From:
Sent: 09 May 2025 10:05
To: DC Admin
Subject: 2025/90814 107 Helme Lane

I wish to express concerns re the application for a dropped kerb.

107 Helme Lane

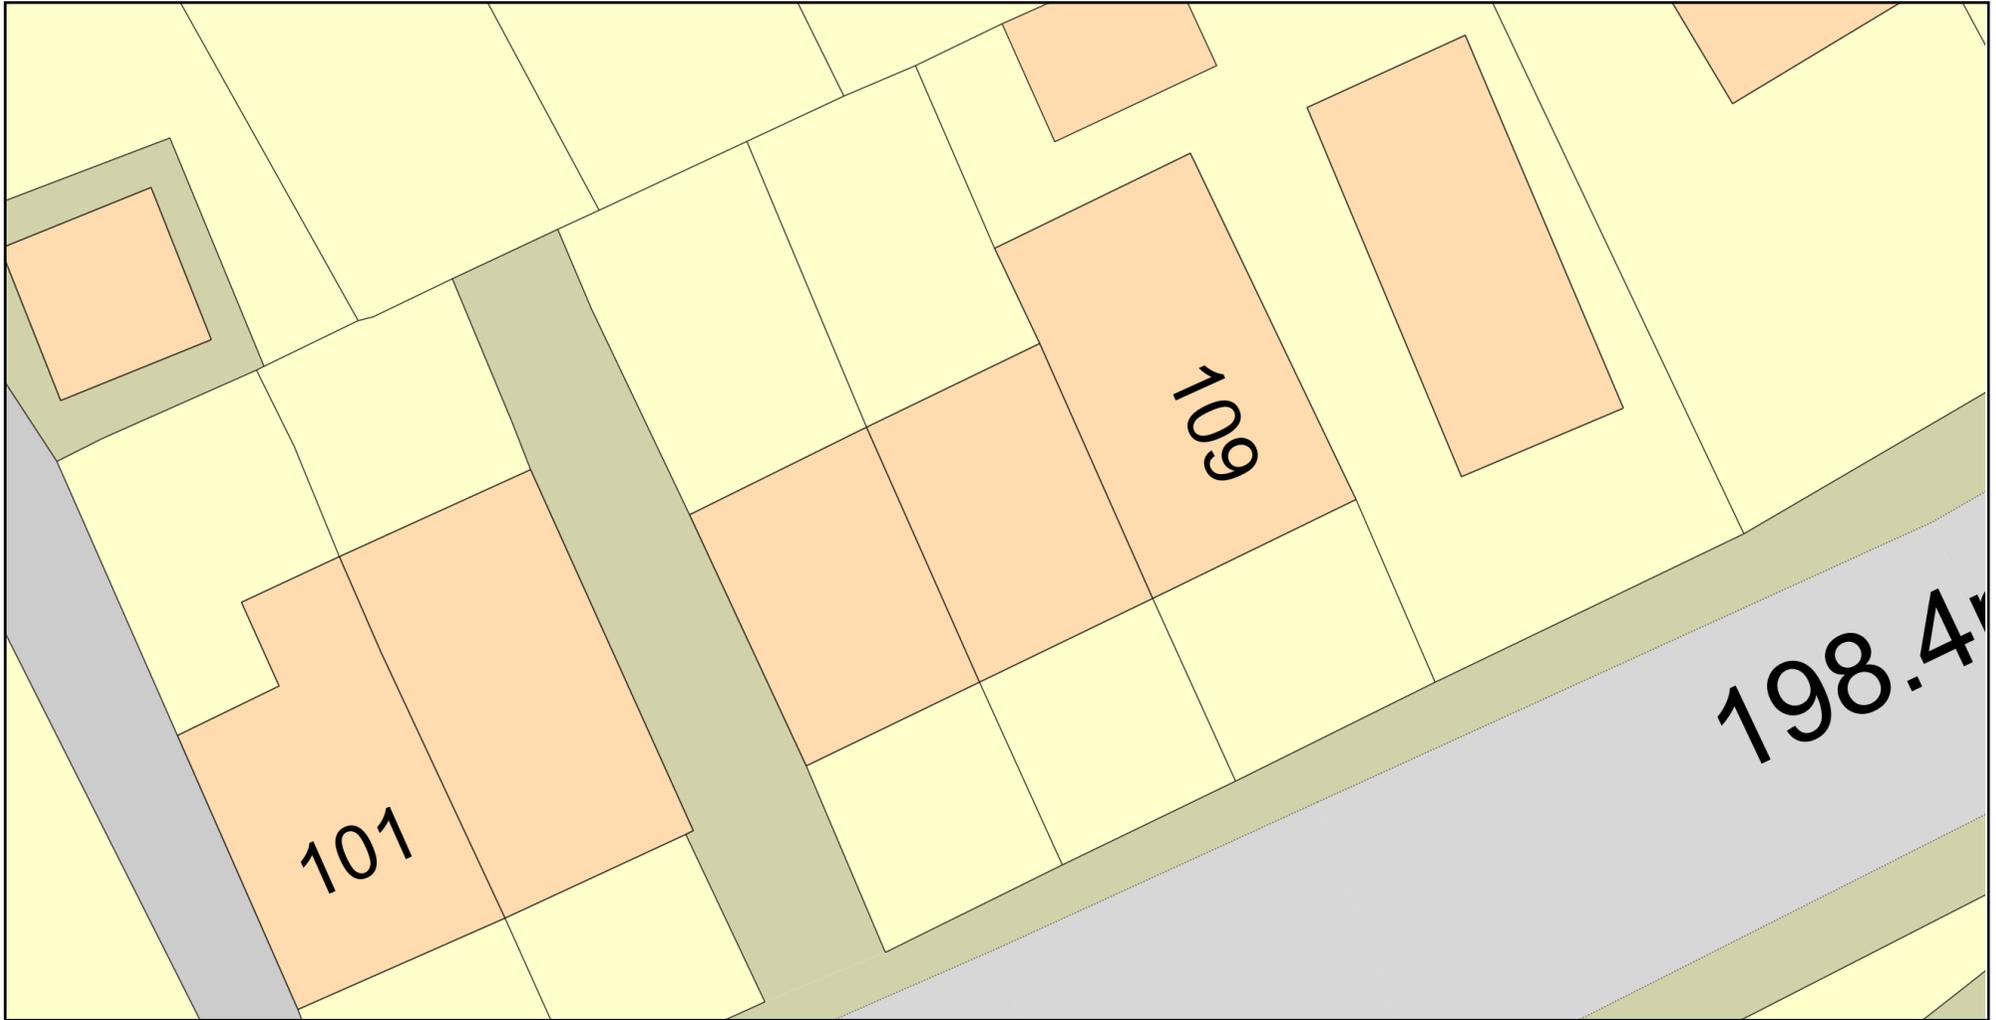
There are three manhole covers on the pavement directly outside the property indicating services/utilities for the road/neighbouring properties.

The property is directly at the junction of Helme Lane and Broadlands. This is a busy junction and when looking online it says that a dropped kerb must be at least 10m from a junction for safety reasons.
